From: Michael Eastham
Sent: 12 March 2019 15:13
To: Planning.Responses
Subject: FW: Saltbox- Drainage - BE/135/18/PL

From: [REDACTED]
Sent: 12 March 2019 14:58
To: Laura Gibbons; Arfon Hughes
Cc: Mr Will Marsh; Keith Sarchett; Chris Thrippleton; Nia Russell; Michael Eastham; Steve hawkins
Subject: RE: Saltbox- Drainage

Subject: Saltbox- Drainage

Project: SBX KSA Z0-XX-DR-C-6260

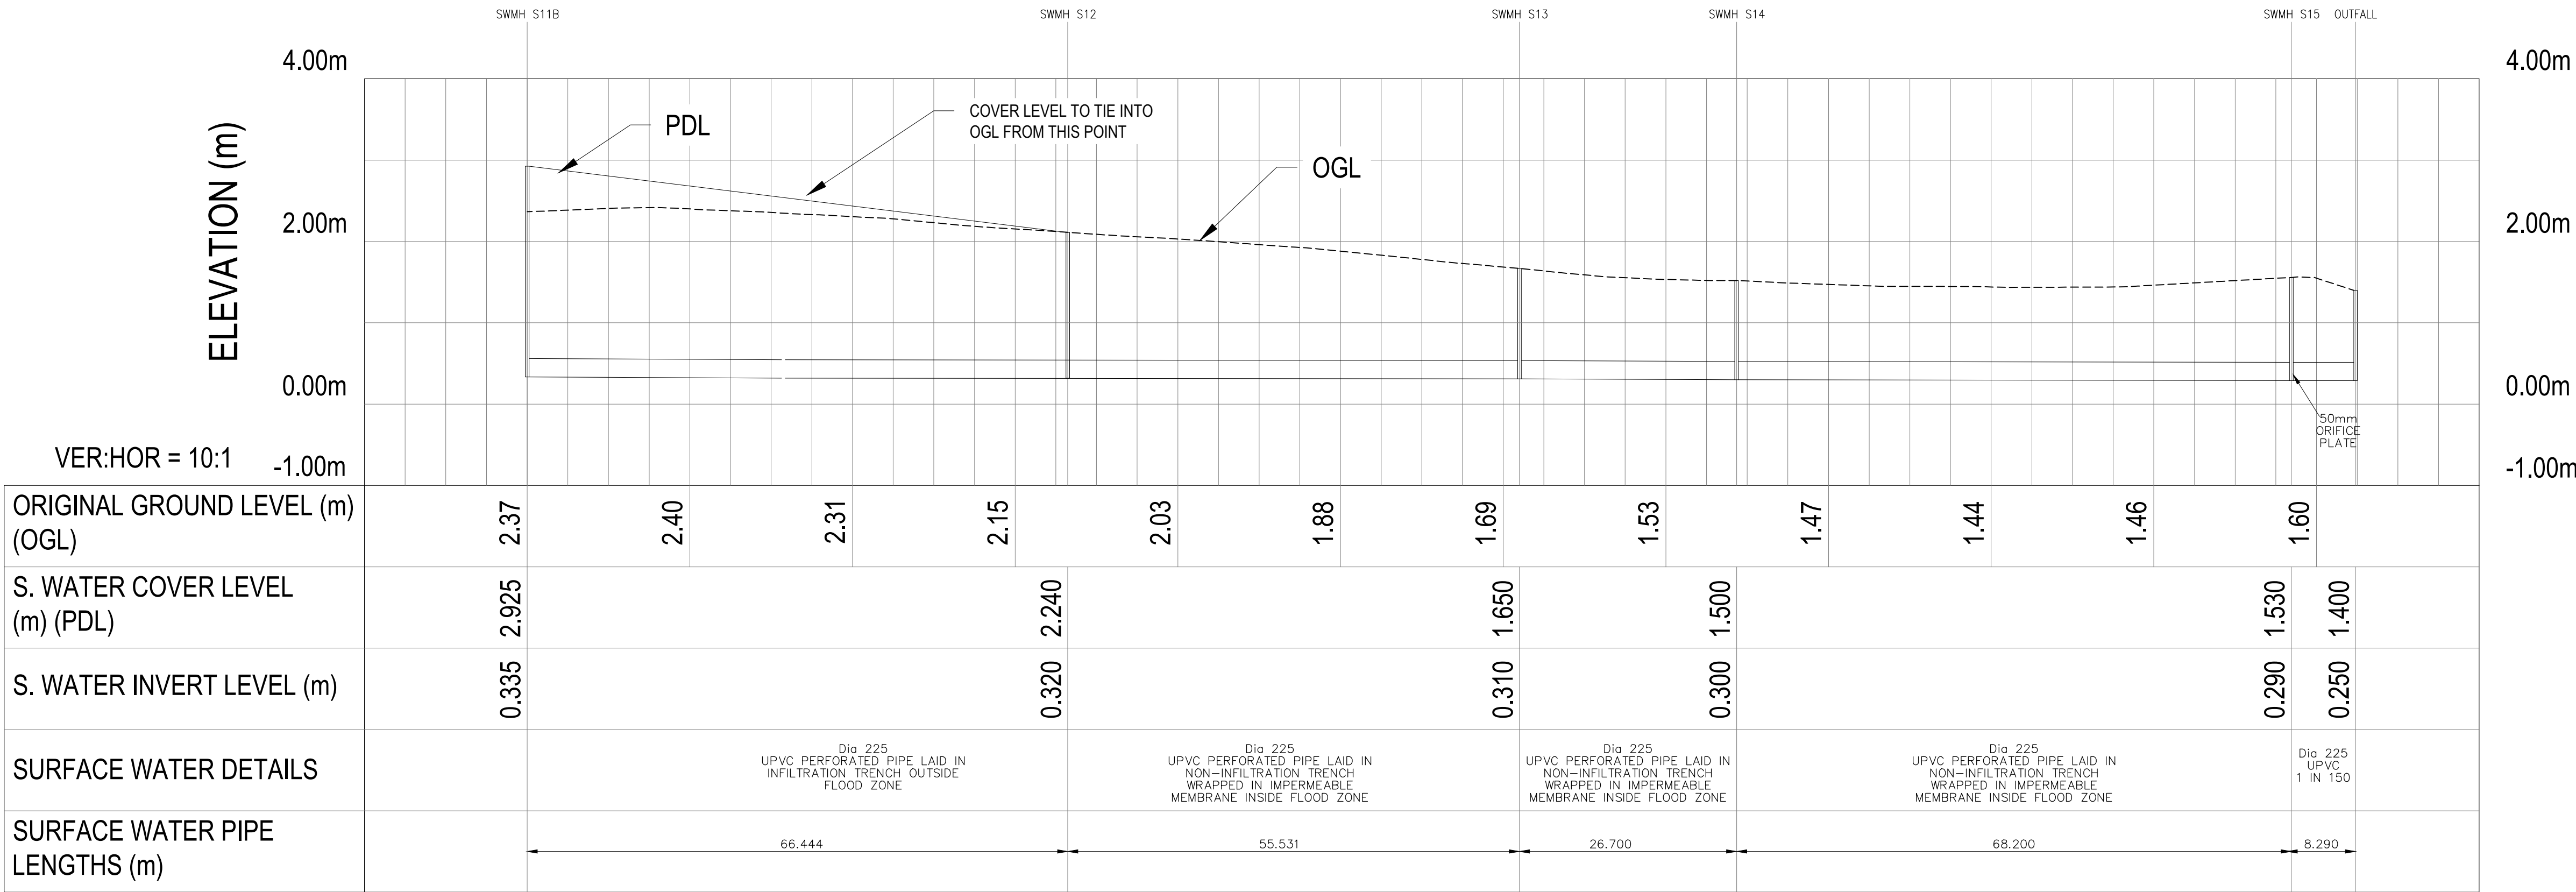
6. No basin or pond is deeper than groundwater level, shallowest ground water depth encountered is 1.37m below ground level(level of -0.020m), deepest basin level is 0.210m. Ground water was struck at 4m below

ground level at the proximity of the deepest pond. See extract from EPS ground investigation report of January 2018 and 2019. All basins are lined with impermeable membrane see drawing 6253 attached. Basins/ponds will not sink because of these reasons. The extracts that have been provided state that extensive groundwater monitoring has been undertaken and that details of the findings will be issued. Please provide these results and ensure they are referenced to AOD. Please also ensure that submissions are complete and do not rely on any information previously submitted (please refer to our checklist for further information).

6. The attenuation basins are proposed to be deeper than groundwater. Therefore the basins will need to be lined. Flotation calculations must be submitted with the DOC application to demonstrate that the design adequately accounts for these forces. If this results in changes to basin footprints revised plans will need to be submitted for BE/135/18/PL.
7. Full details must be submitted of how adequate treatment of surface water is to be achieved via the proposed surface water drainage scheme.
8. A maintenance manual should be submitted.
9. The DOC application (BE/2/19/DOC) should be submitted in full accordance with the advice within the drainage submissions checklist (attached for ease of reference). If pre-commencement conditions are to be avoided on the other application (BE/135/18/PL) the detailed submitted will need to be to level set out within the drainage checklist.

4. Further readings of the ground water have been received from EPS (see report attached). The highest ground water level 0.413m below ground level was recorded at the southwest corner of the site (BH1). Floatation calculations on drawing (6256 attached) show that there is a buoyancy pressure of 5kn/m^2 spread over the basin area, our proposal is to install 200mm thick stone over the impermeable membrane to keep it in place during heavy rainfall when the ground water is at its highest.
Please find attached completed checklist as requested. Calculations for the permeable paving half drain times for 1 in 10 years + 40% and 1 in 100 yrs + 40% for the basin have been attached.
Storm network analysis for 1 in 1, 1 in 2, 1 in 30 and 1 in 100 year + 40% have also been attached.
